Recommendation Report for Planning Permission for Works or Extension to a Dwelling

REF NO: R/109/19/HH

LOCATION: 28 Mill Lane
Rustington
BN16 3JN

PROPOSAL: To form bedroom 4 over kitchen.

Job Title
To form New
Bedroom No.4
Over Kitchen extension

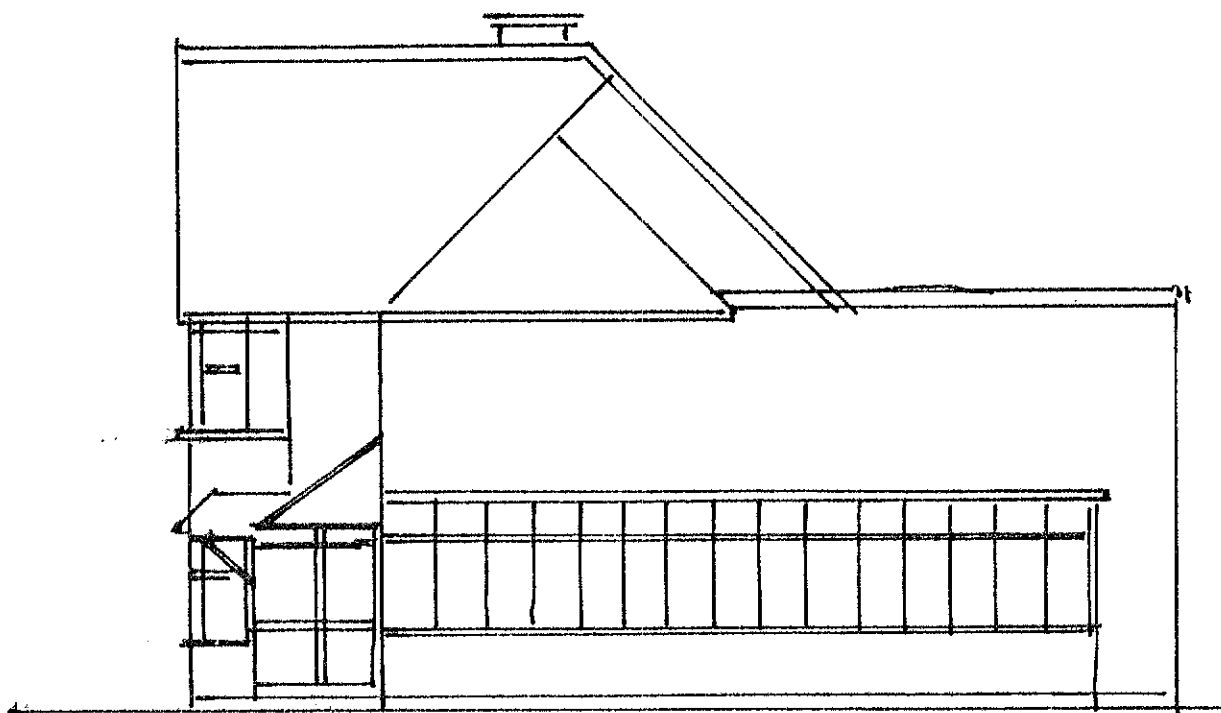
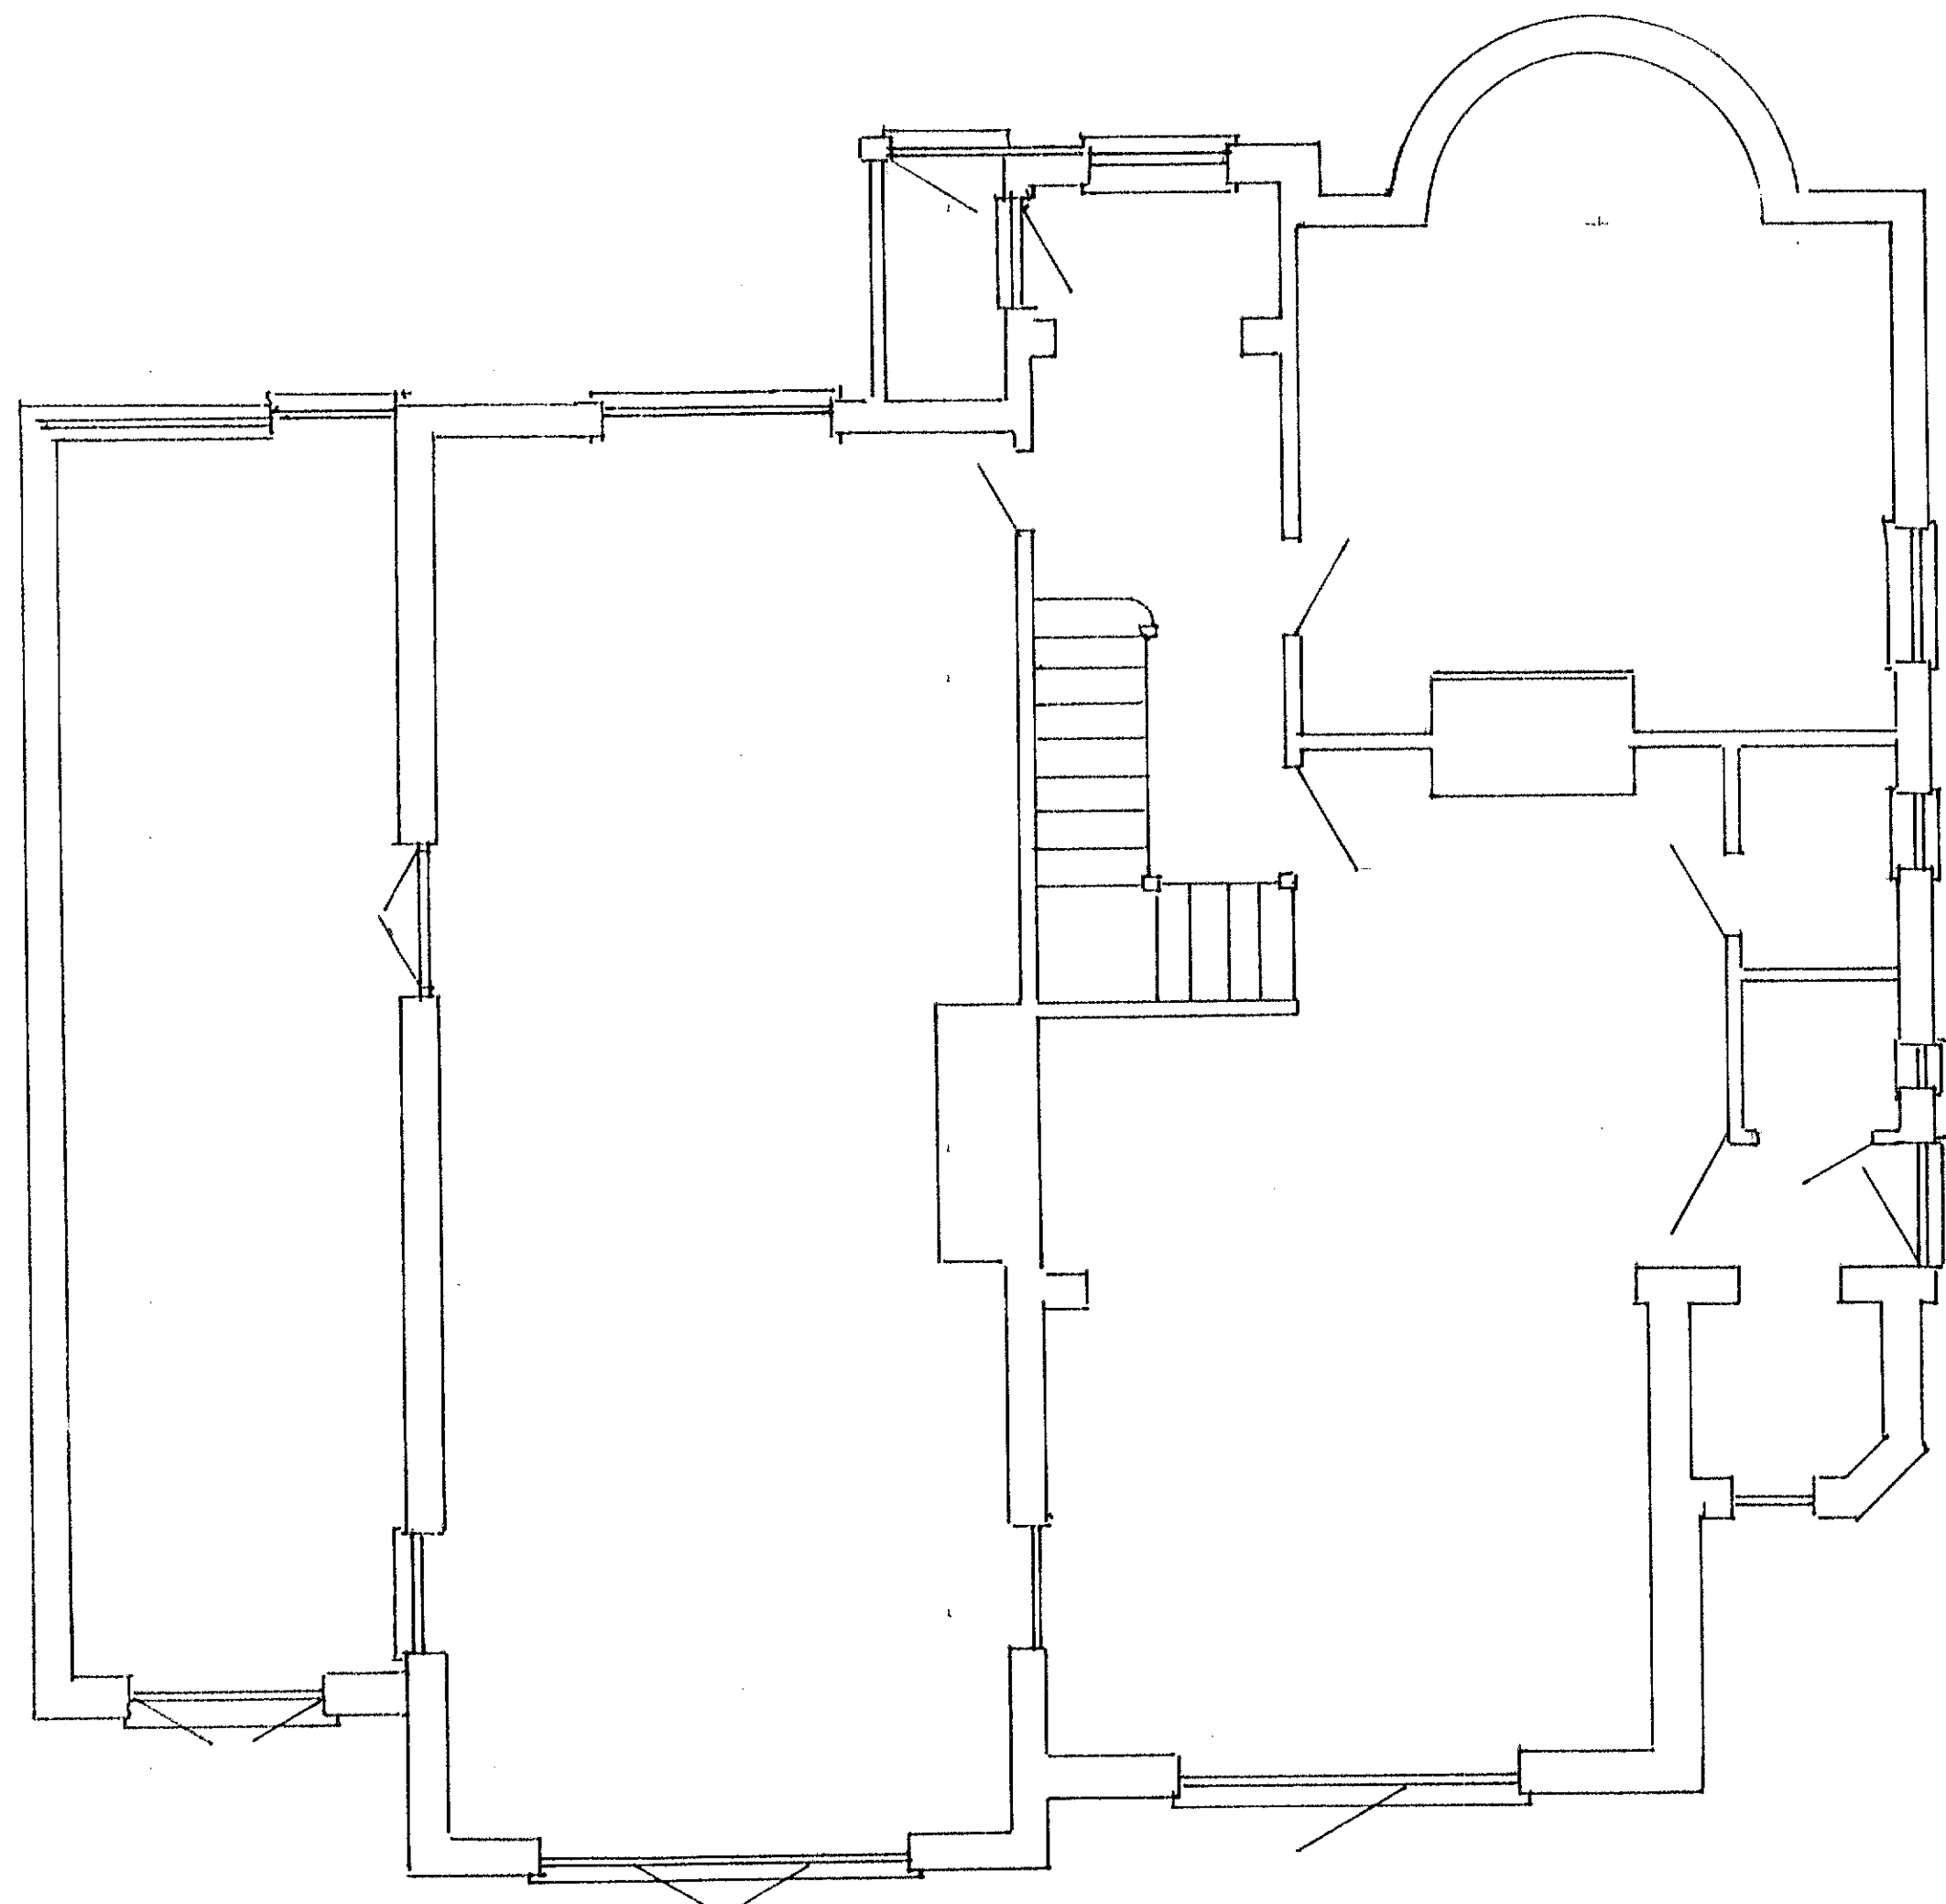
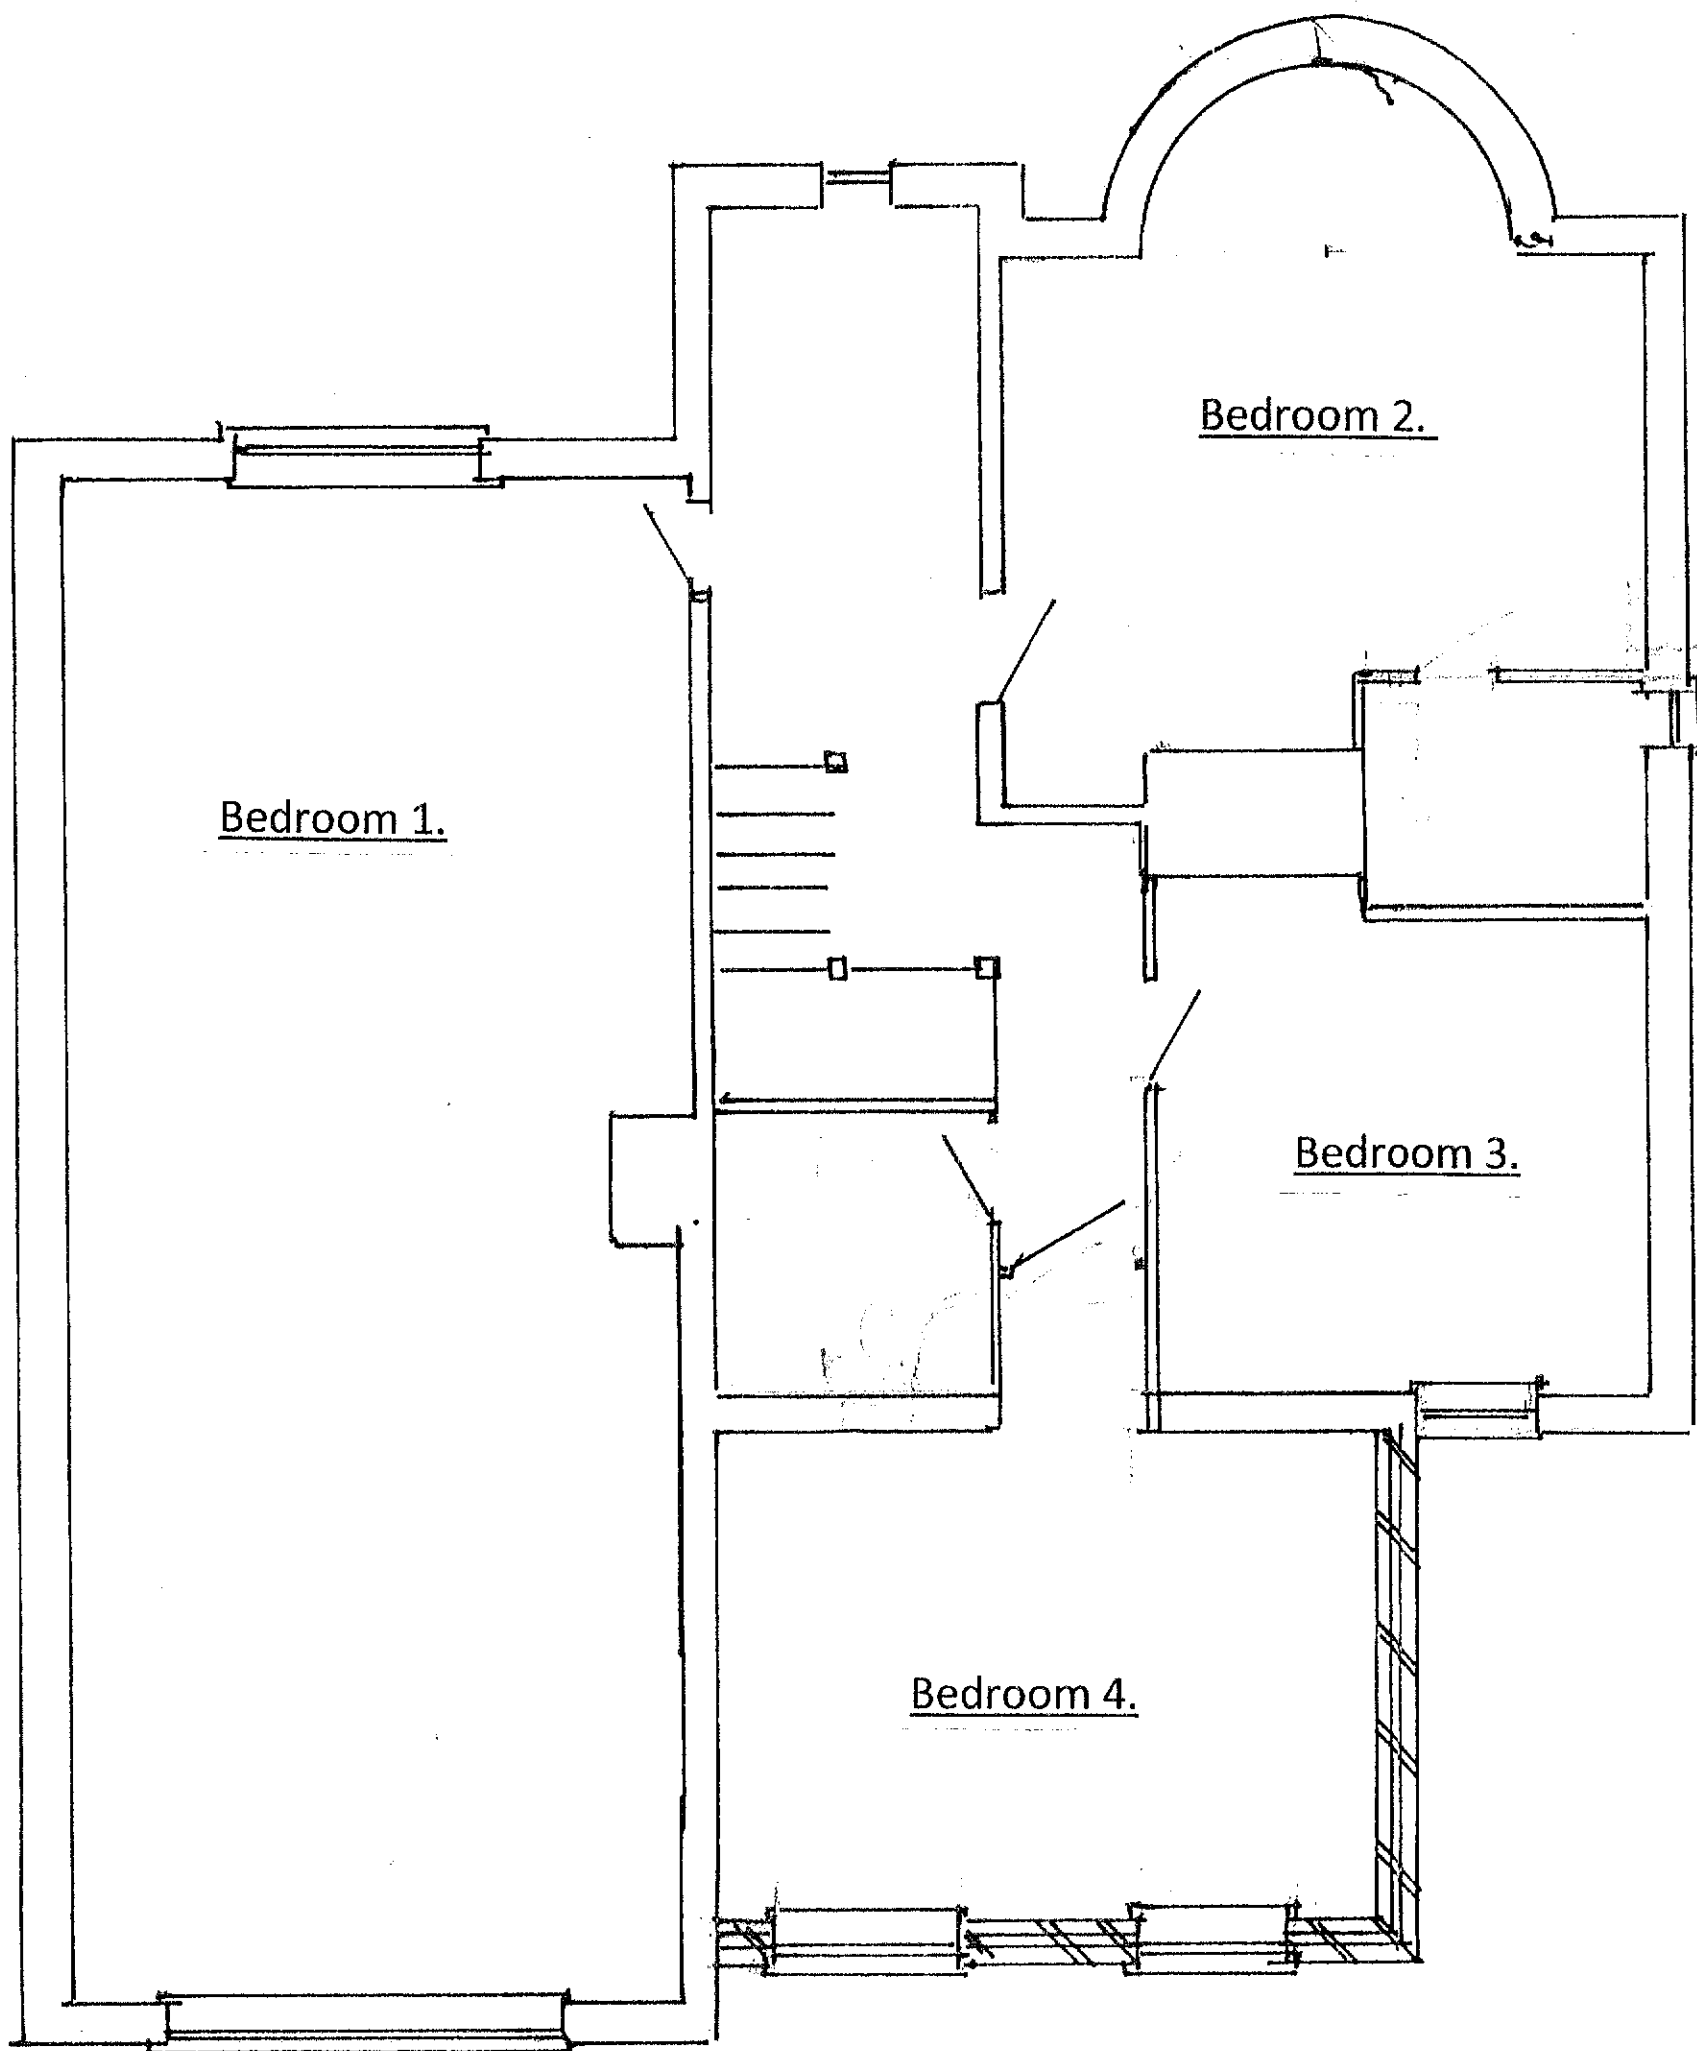
The development to the rear of the dwelling is of a large scale and the addition of a first floor will increase the height of the existing extension by around 2.8m. The extension would have a depth of 4m and width of around 4m which is the same as the existing.

Impacts such as the potential overbearing and loss of light needs to be assessed in which the council use a 45 degree rule to assess overbearing impacts. The rear facing windows of 30 Mill Lane to the northern elevation would be impacted however the first floor extension would not breach a 45 degree line drawn from the centre of the rear facing windows and therefore with respect to the rear facing no significant adverse overbearing impact or loss of daylight would be caused as a result.

At the eastern elevation 2 windows would be installed however due to their location, they are not considered to give rise to any loss of privacy or overlooking.

The properties to the rear of the dwelling are in excess of 50m from the rear elevation of the proposed first floor extension and it is not considered the development will give rise to any overlooking impacts.
